Our Ref: R/2016/1/D
File No: MP 08_0098 MOD 13

The Star (MP08_0098 MOD 13) – 20-80 Pyrmont Street, Pyrmont – Response to Submissions

The City of Sydney (the City) has reviewed the RTS and maintains its **objection** as the issues raised in the City's letter dated 9 October 2018 remain unaddressed. The following additional comments are provided for your consideration:

DRAWING NO.
L400

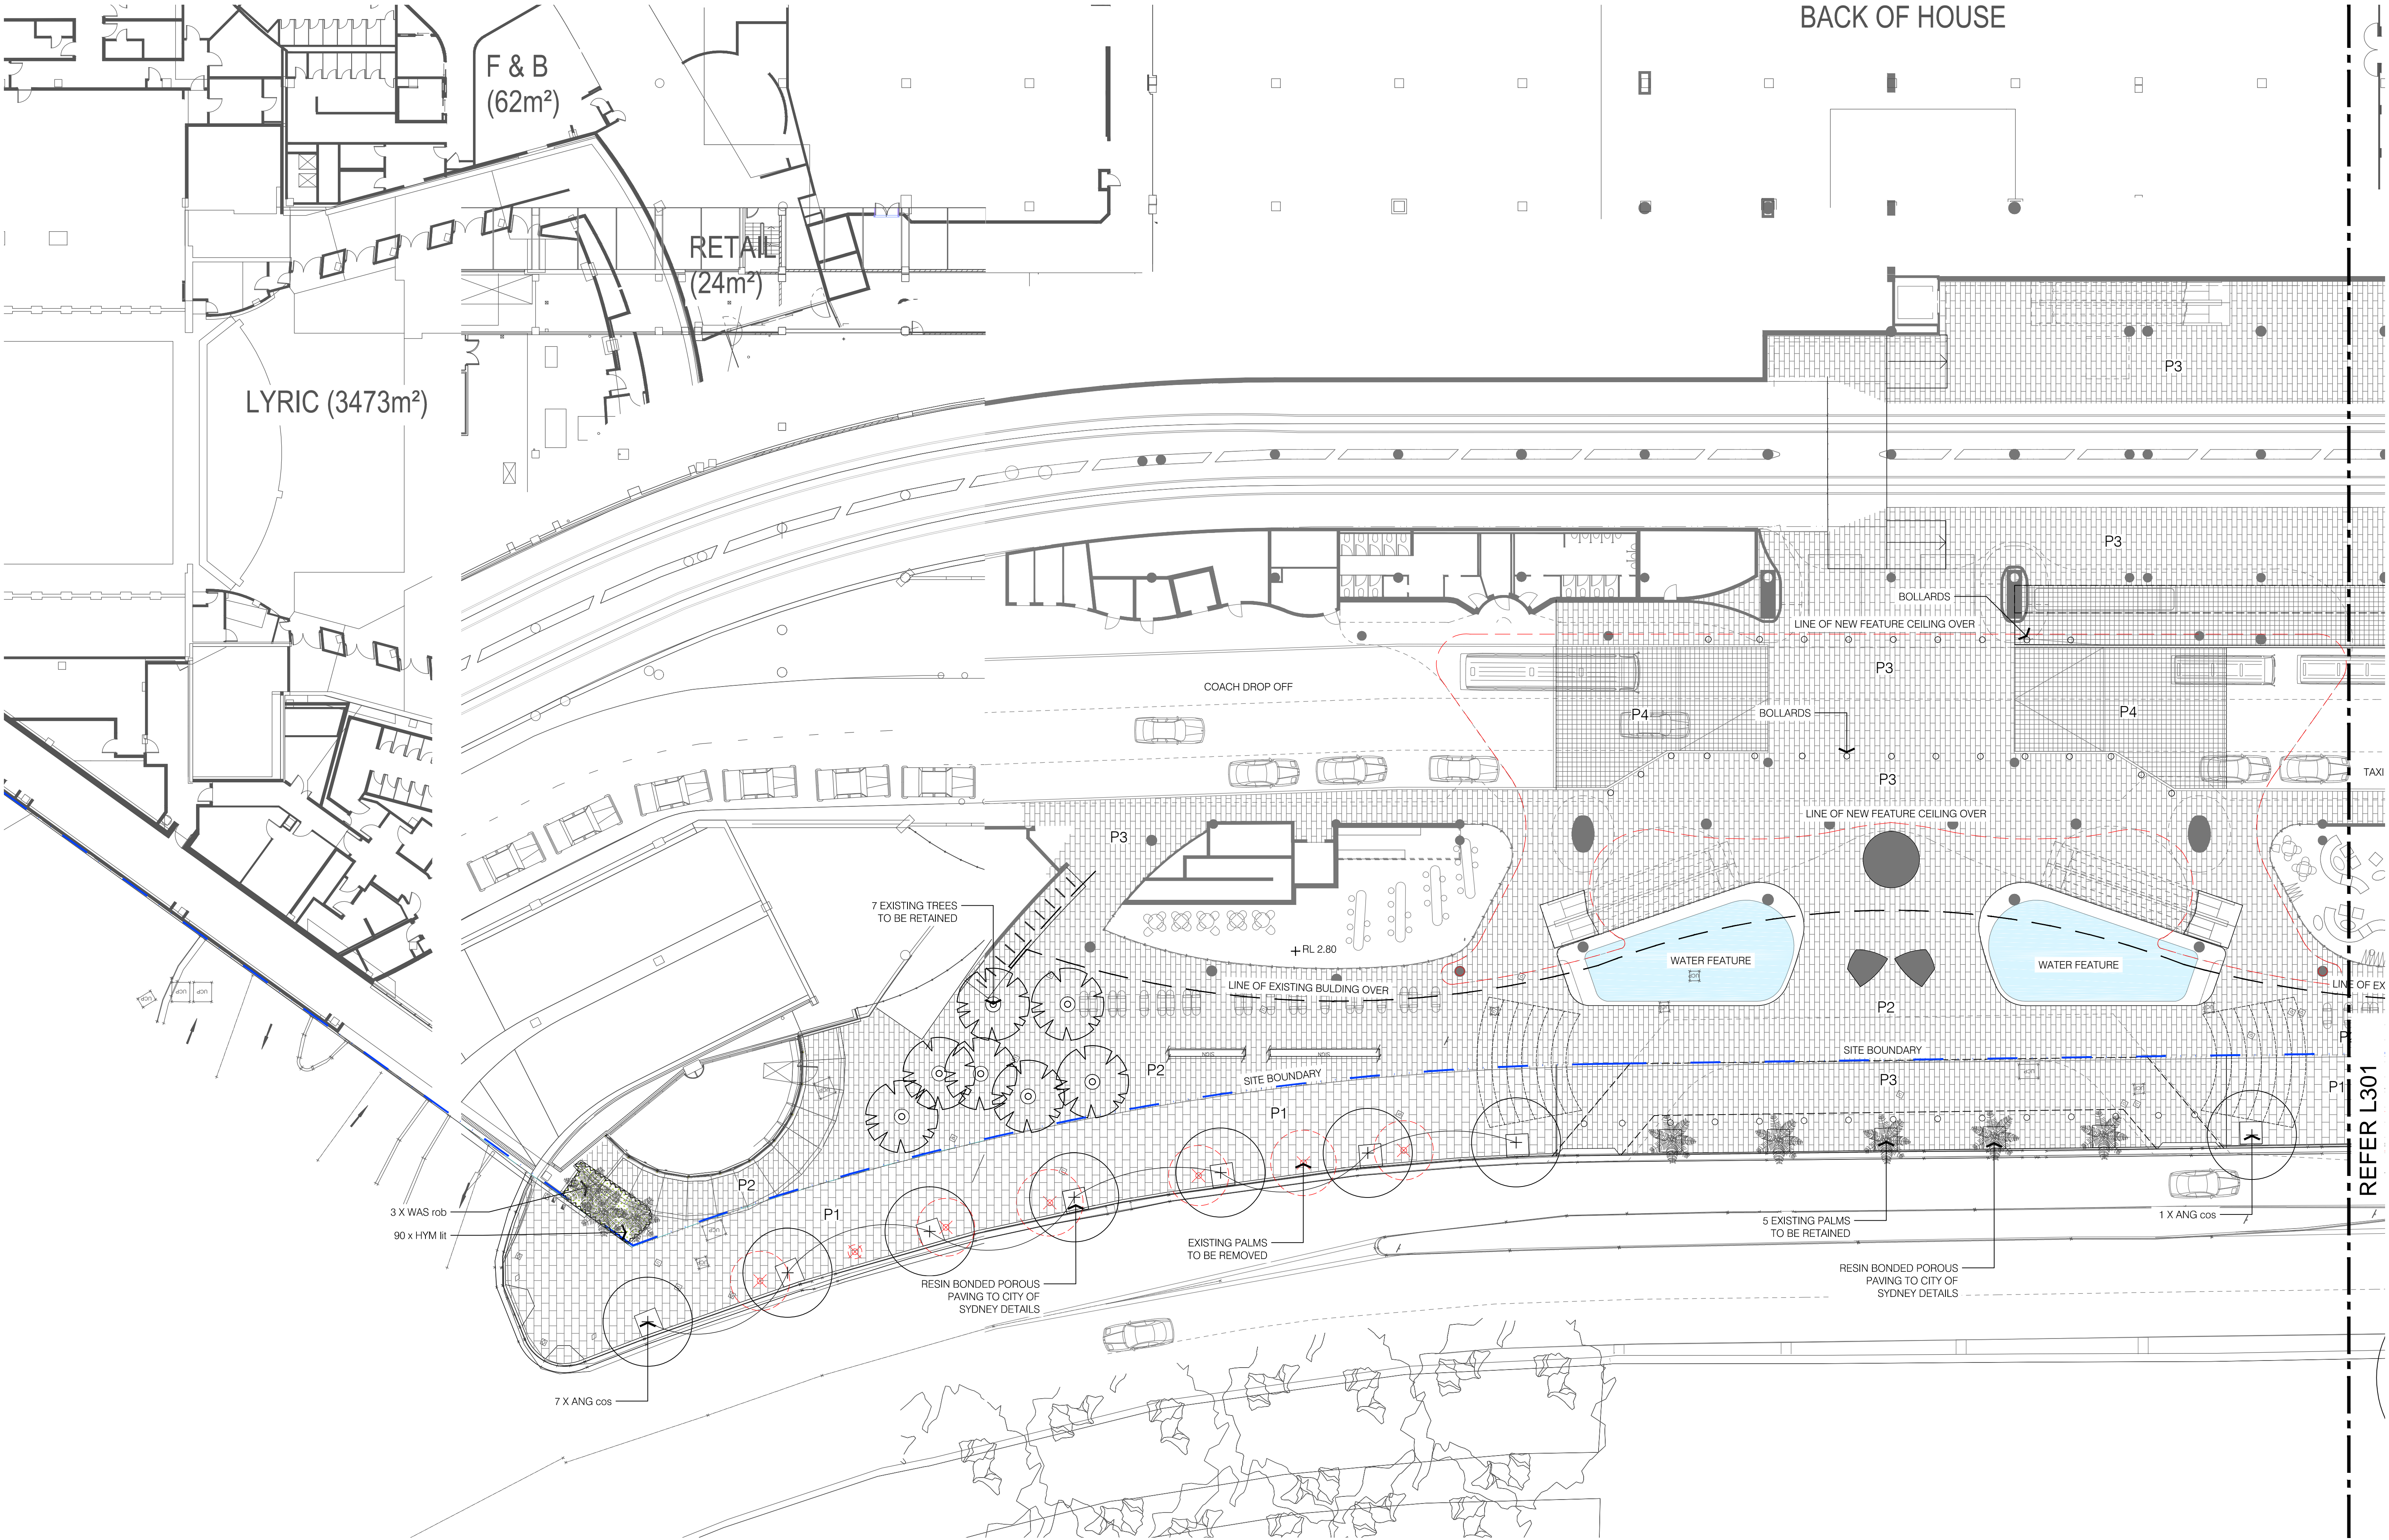
A new planter at the southern end of the Pirrama Road frontage, adjacent to the car park entrance, is proposed with this submission. The planter bed spans private and public land raising questions of maintenance and liability. The planter should be reconsidered or reduced in size (refer Dwg: L400 B). Any proposed use of public land will require separate approval of the City.
